Application ref: Y/180/21/PL

Description: Variation of condition following grant of Y/141/21/PL relating to Condition 2 - approved plans. This application may affect the setting of Listed Buildings and may affect the character and appearance of the Main Rd/Church Rd Conservation area and affects a Public Right of Way.

Location: Land East of Drove Lane Yapton BN18 0EB

Summary recommendation: Recommend **no landscape objection** to variation of condition following grant of Y/141/21/PL relating to Condition 2 - approved plans.

Drawing Title:
SALES CABIN
LOCATION PLAN

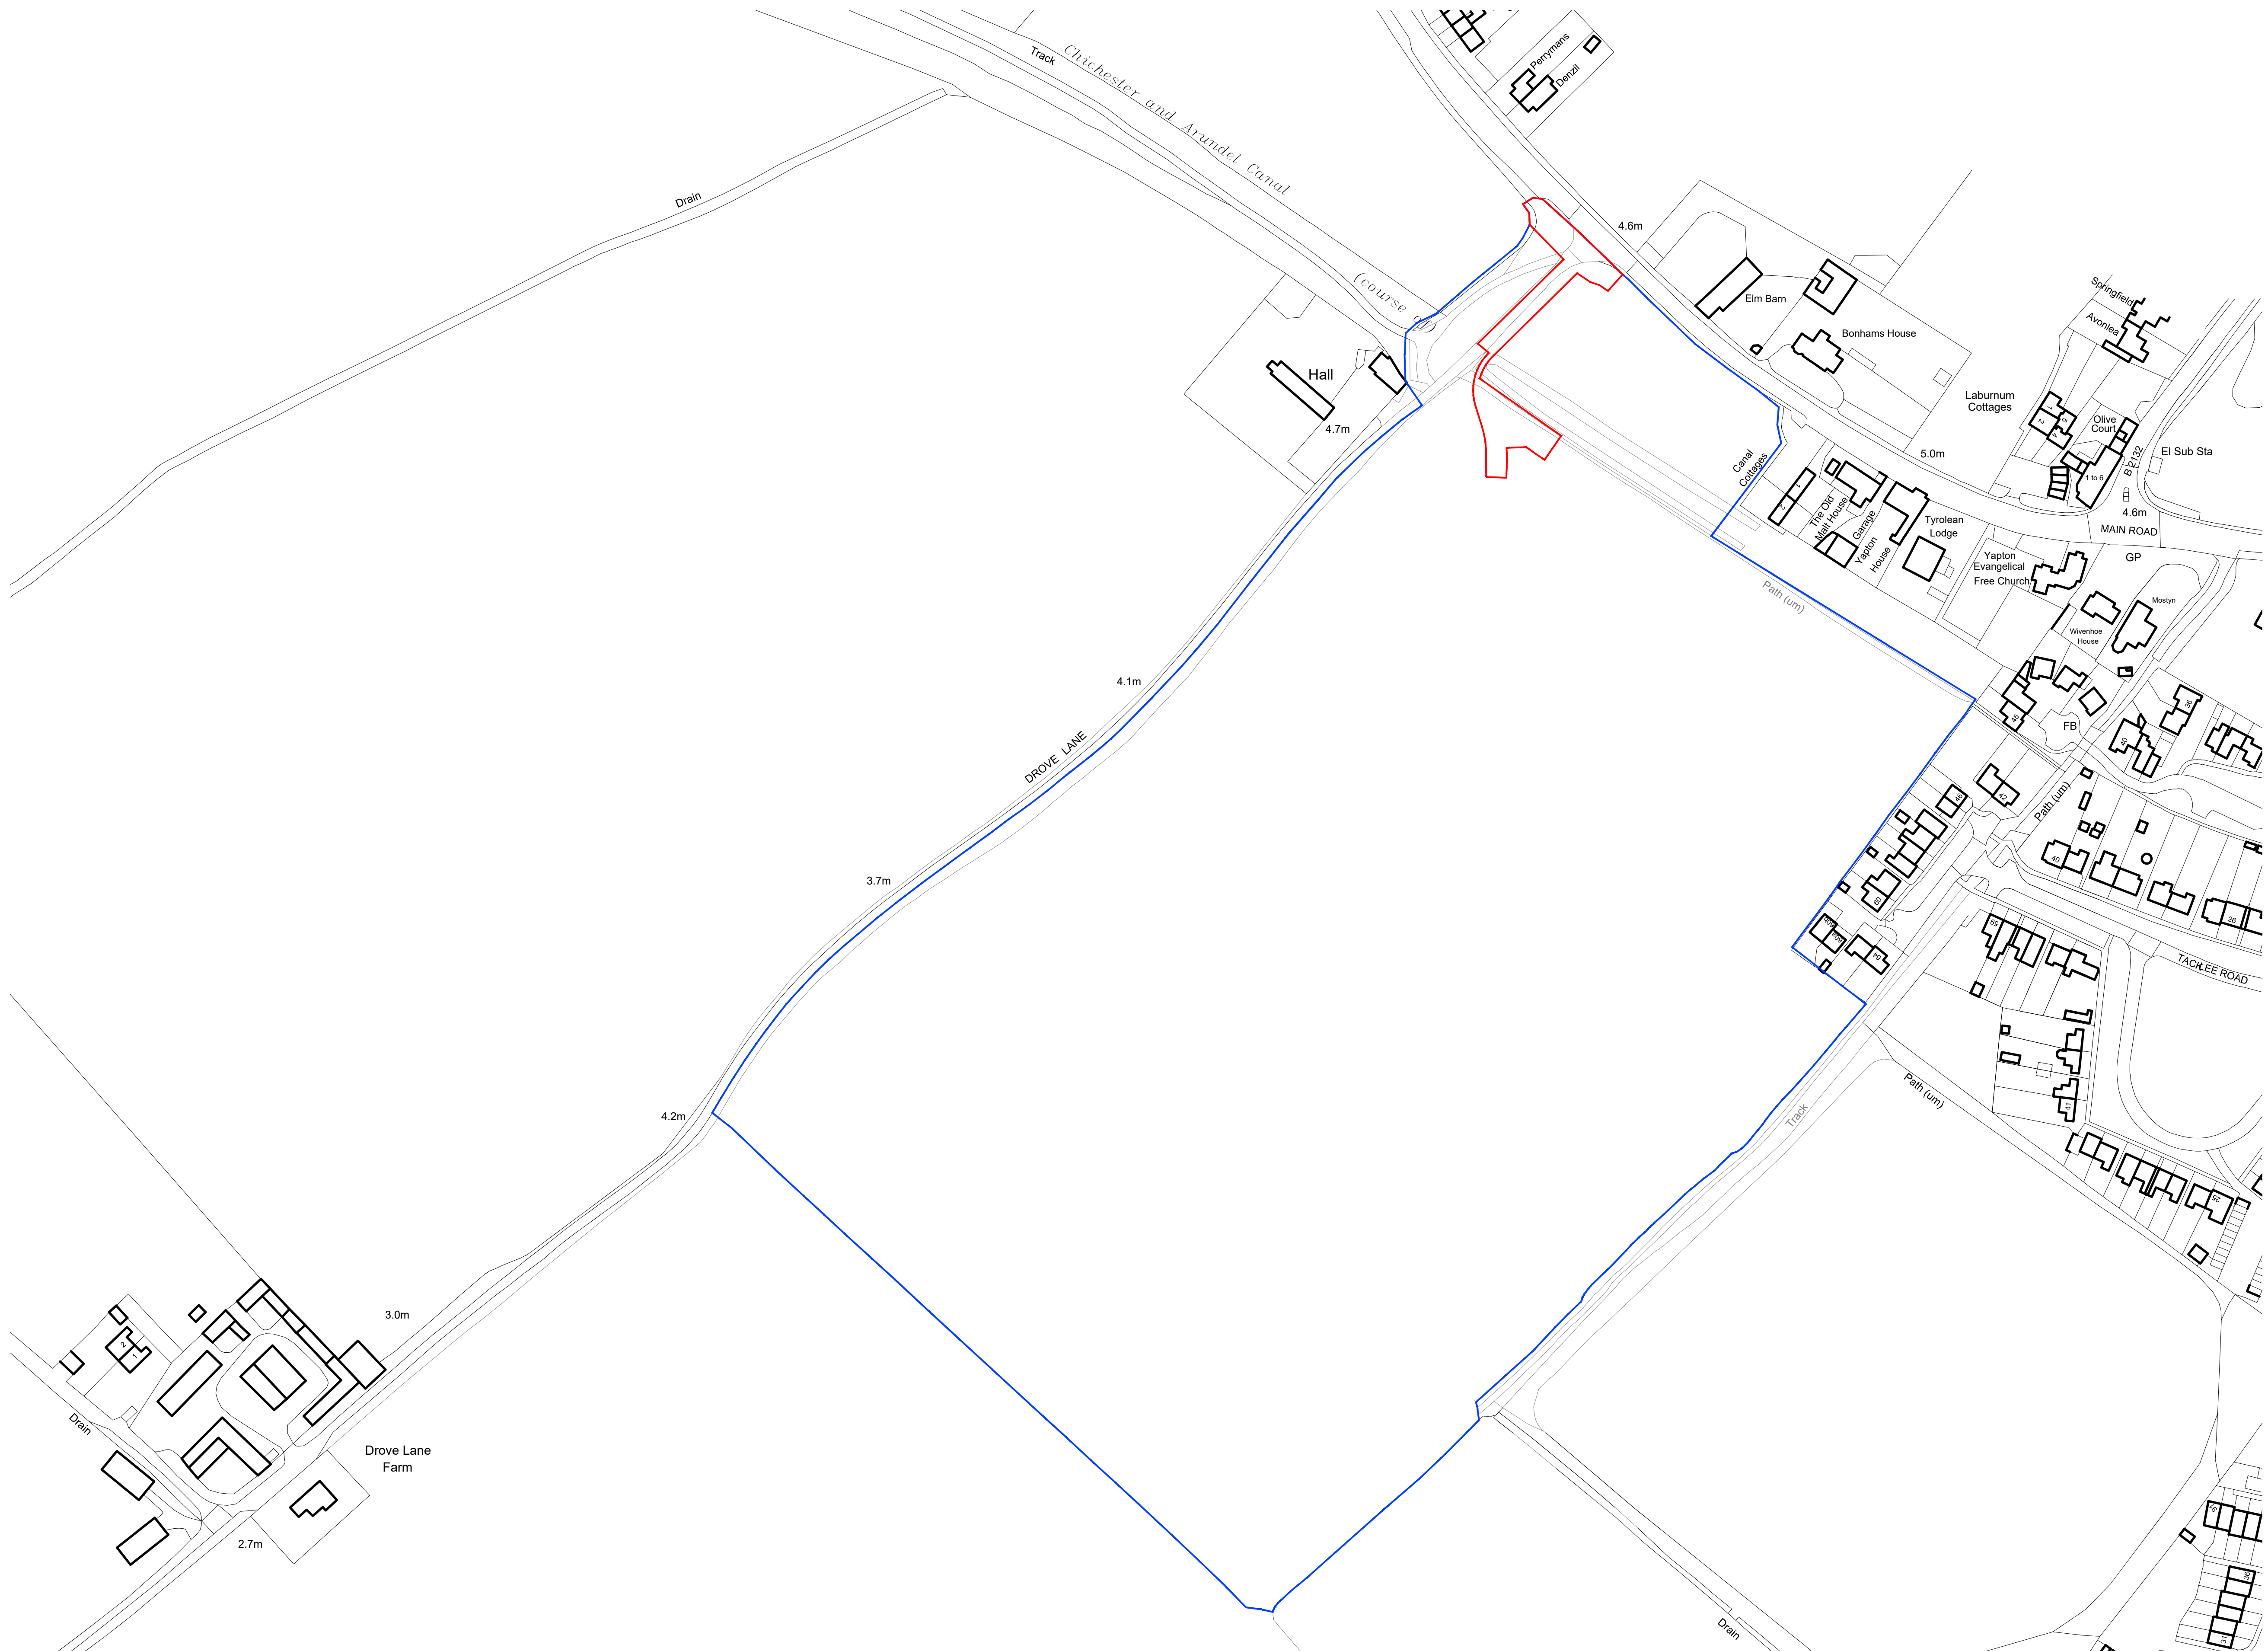
The proposals to Sales cabin location and pathways and details contained within Detailed Landscape Proposals Dwg JBA 19/291-11 Rev C would appear appropriate and would recommend no objection.
